Application number: 2020/92400	
What is the application for?:	Erection of detached garage
Address of the site or building:	Brigsteer, 402, Birkby Road, Birkby, Huddersfield, HD2 2DN
Postcode:	HD2 2DN

An Objection to Planning application 2020/62/92400/W

PROPOSED SITE PLAN 1:200
AFTER JUNCTION IMPROVEMENT WORKS 1:200

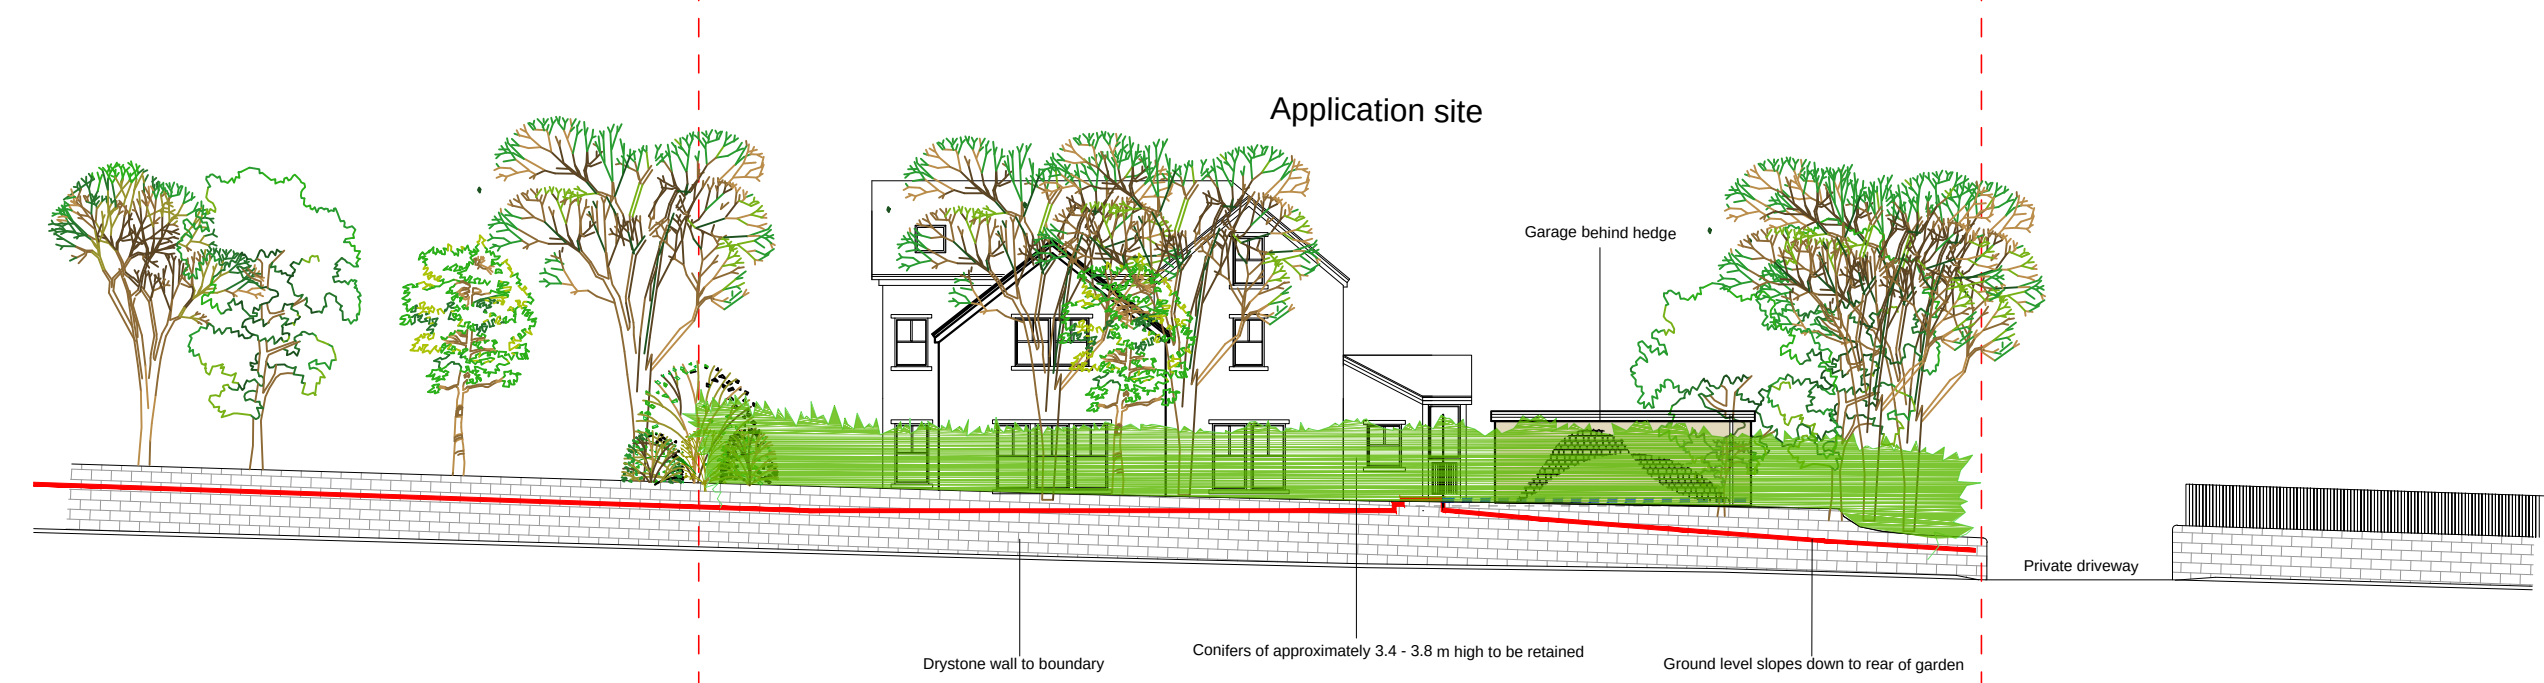
The planning application is only slightly amended in size from the previous application Application Number: 2019/62/91842/W which was refused last year both by the council and on appeal. The new plans for a proposed garage is still forward of the host property and adjacent to Birkby Road and combined with the previous extensions undertaken at the application site would still represent an overdevelopment of the site as per the refusal statement on your planning portal. (See below)

I would like to draw the planning committee's attention to the fact that no other property down both sides of Birkby Road has a garage situated forward of the property so close to the boundary wall with Birkby Road. This will be even closer when the proposed changes to the junction of Birkby Road and Halifax Road are completed.

PROPOSED SITE SECTION (VIEW FROM BIRKBY ROAD) 1:200

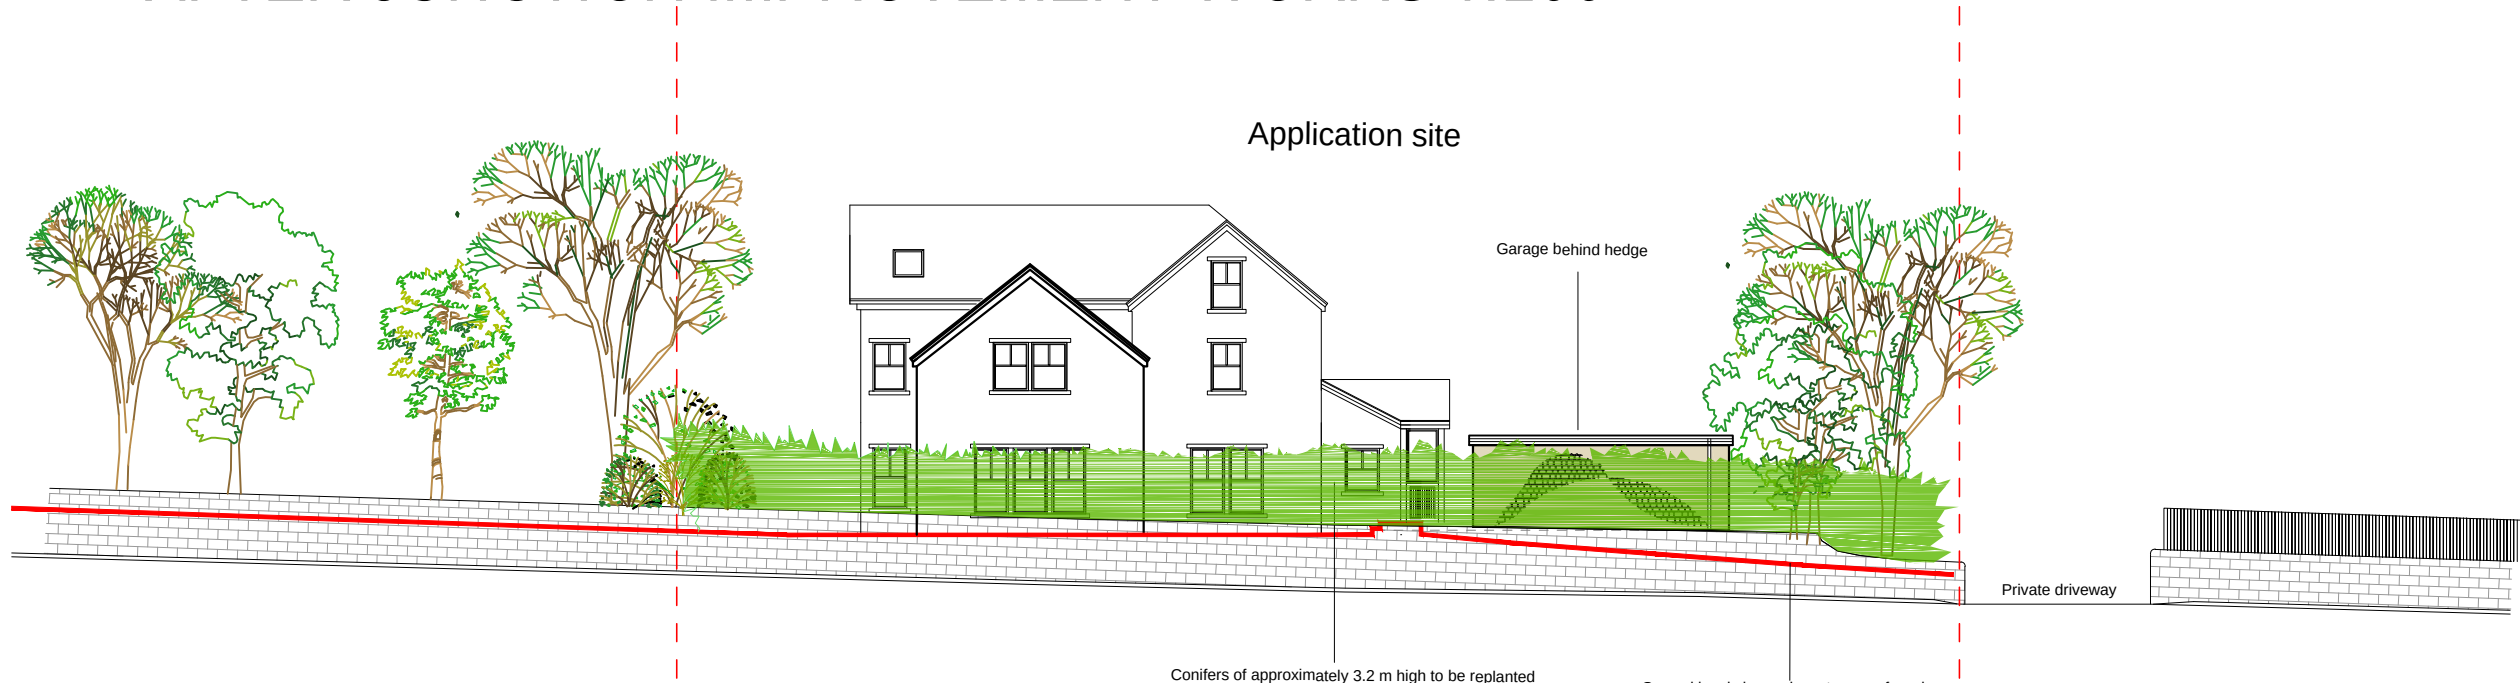
My second reason for objecting is the plans submitted are misleading. The proposed height of the garage on the drawings is drawn to give the impression it is lower than the level of the roof above the entrance to the property. This is incorrect, the height of the roof towers over the entrance to the property.
